Your Ref: OWPC16551
Our Ref: FG/174/17/PL 07-11-2017
Please ask for:
Mrs A Gardner

Demolition of existing dwelling (No. 32) & erection of 4 No. 4 bed dwellings, alterations to existing dwelling (No. 34A) with alterations to two existing accesses to form a single point of access. This application may affect the Character & Appearance of the Ferring Conservation Area.

32 & 34A Sea Lane Ferring

Thank you for your internet representation made on 12th December 2017 which has been recorded as '**an objection**' with the comments as follows:

DRAWING TITLE
Proposed Site Plan, Location Plan
and elevation from south

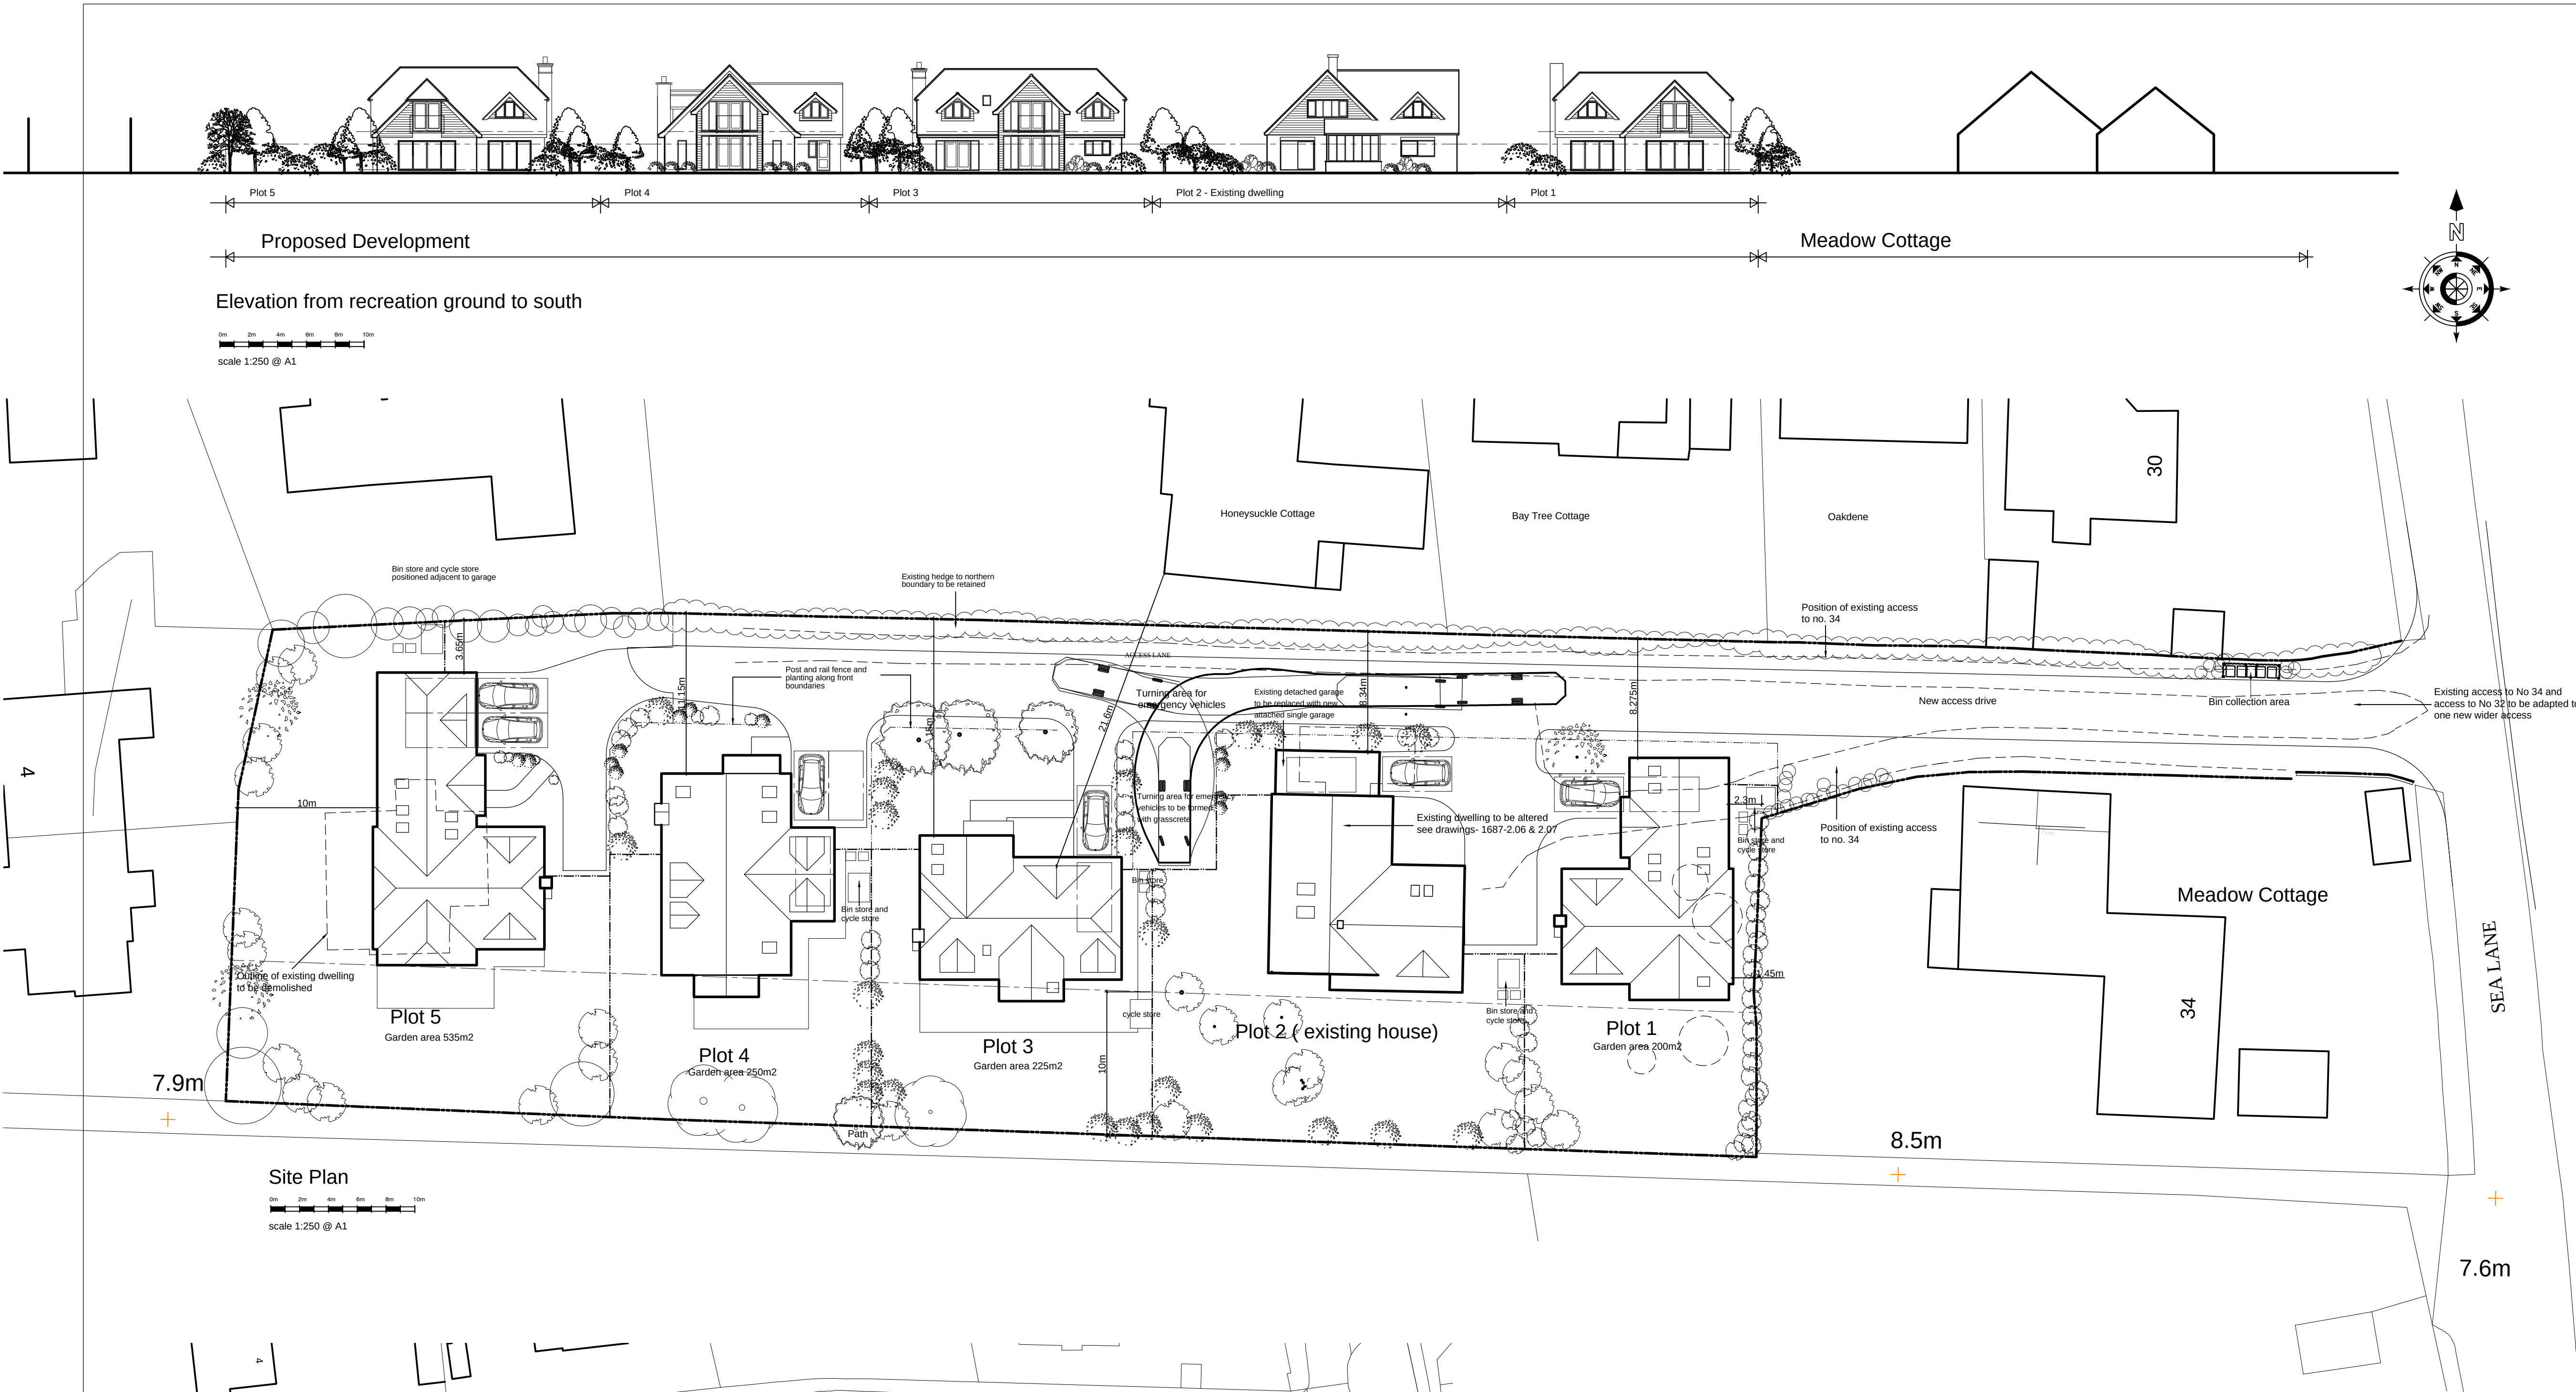
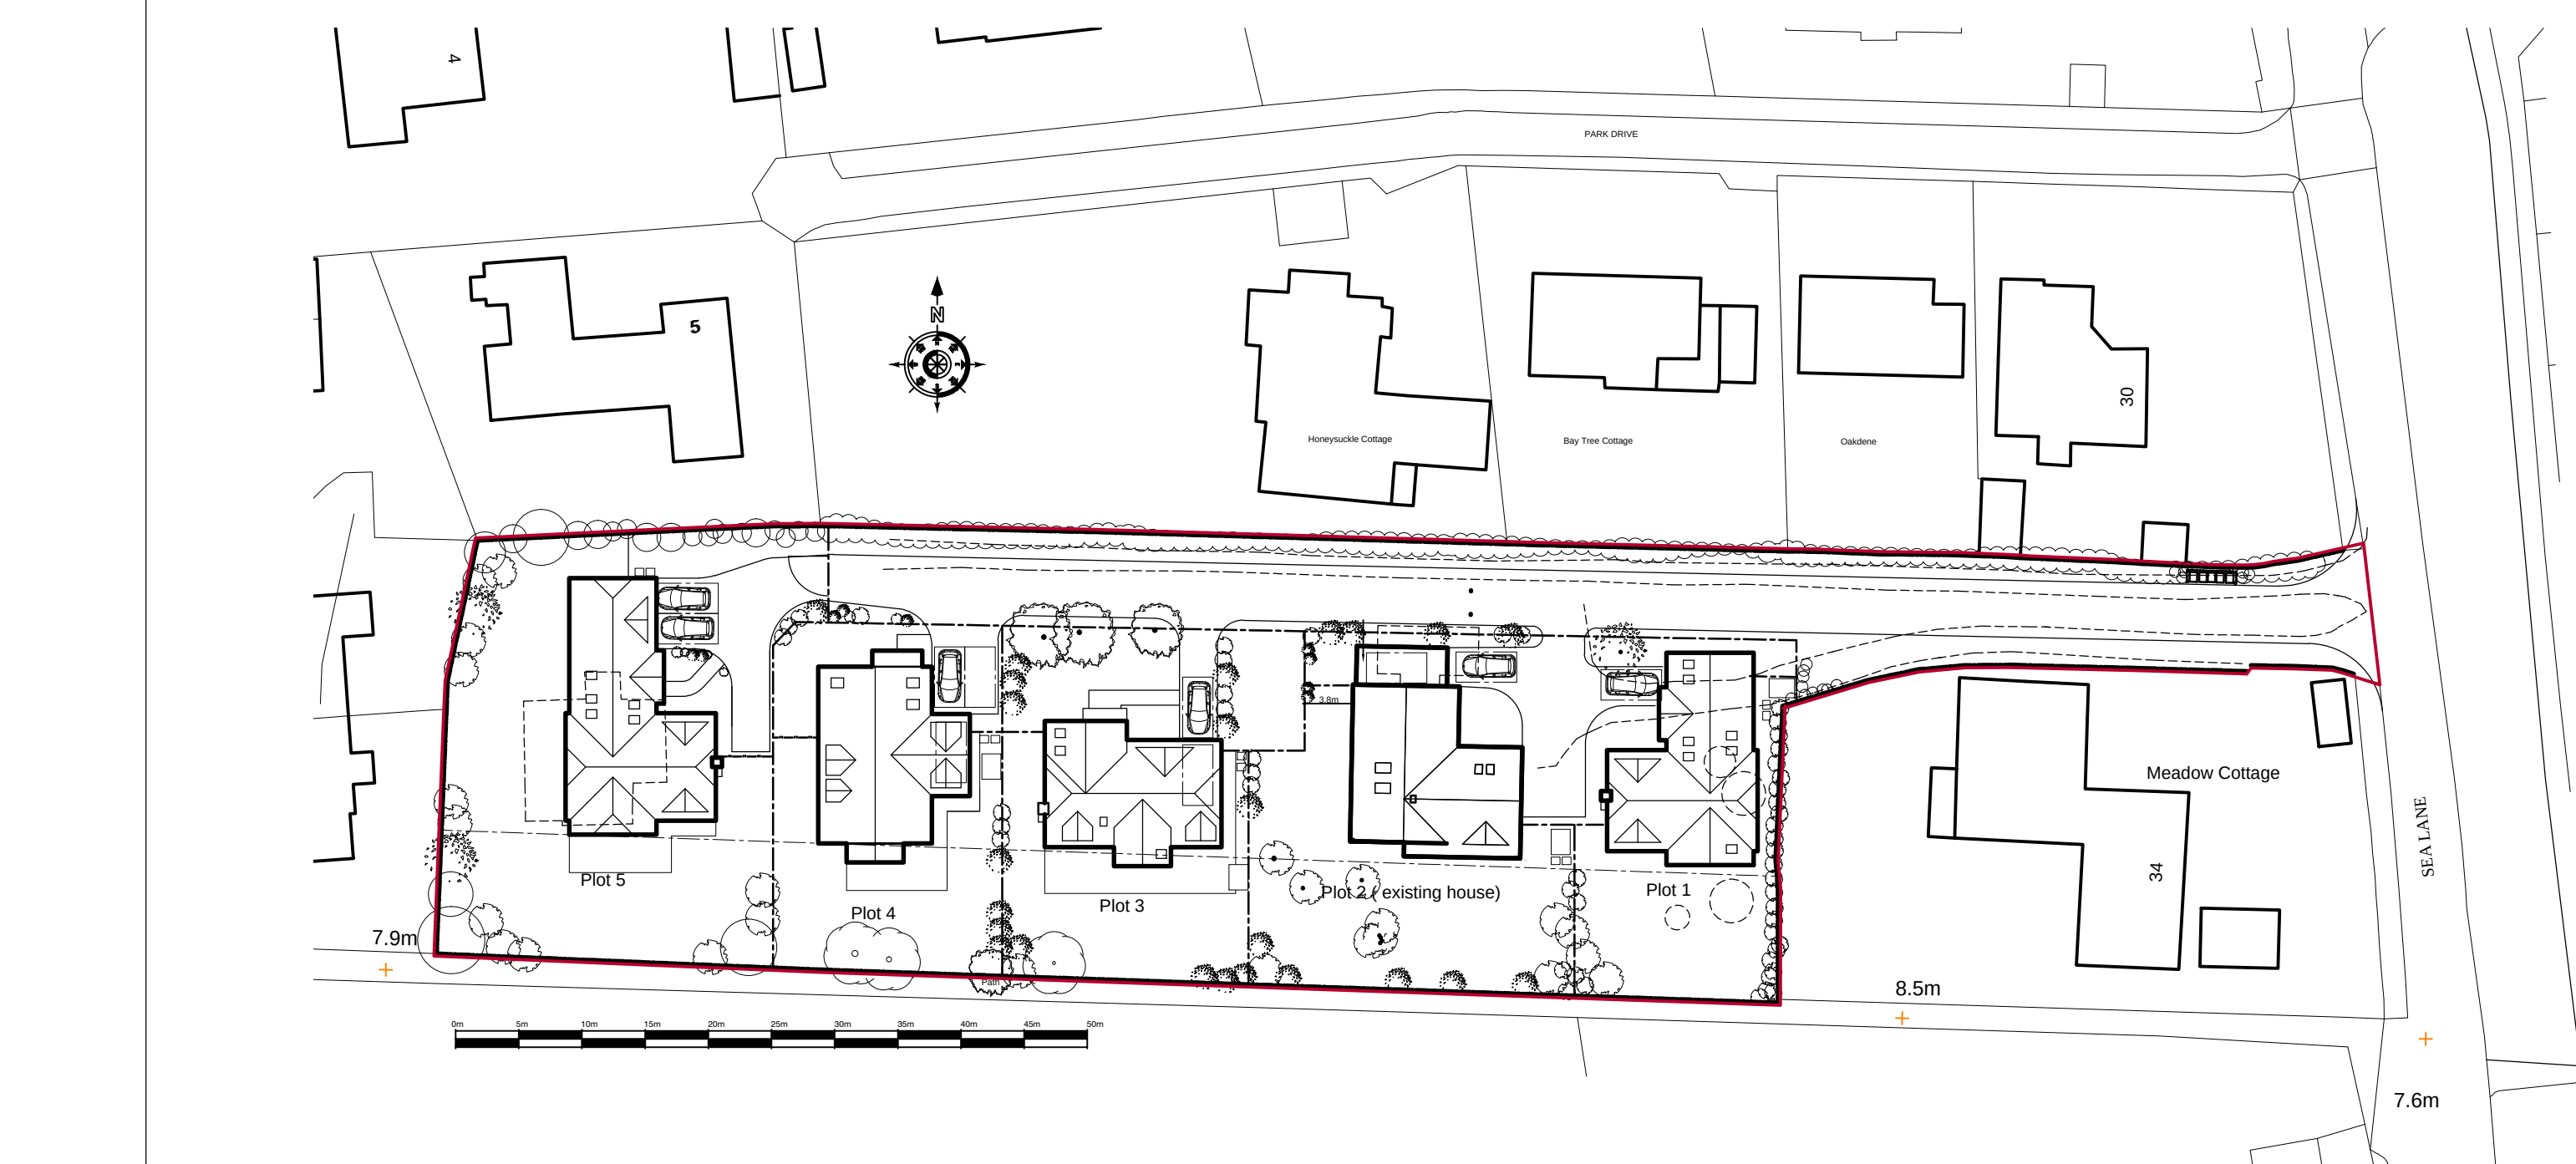
This is clearly an overdevelopment of the site. The access and parking is insufficient for 5 large properties with deliveries, visitors and multi car households. There is no overflow parking.

Access onto Sea Lane at this point would be particularly hazardous since the East side of Sea Lane is regularly blocked with parked cars putting this access in the centre of what becomes a narrow single track lane.

There doesn't seem to be a footpath on the side of the long access track and the applicant suggests 2 cars can pass - what would the pedestrian do at this point ? What about a pedestrian in a wheelchair or with a pushchair ?

The applicant shows splays onto Sea Lane which cross the land of other properties and the current visibility cannot be guaranteed as these corners are not within the control or ownership of the applicant.
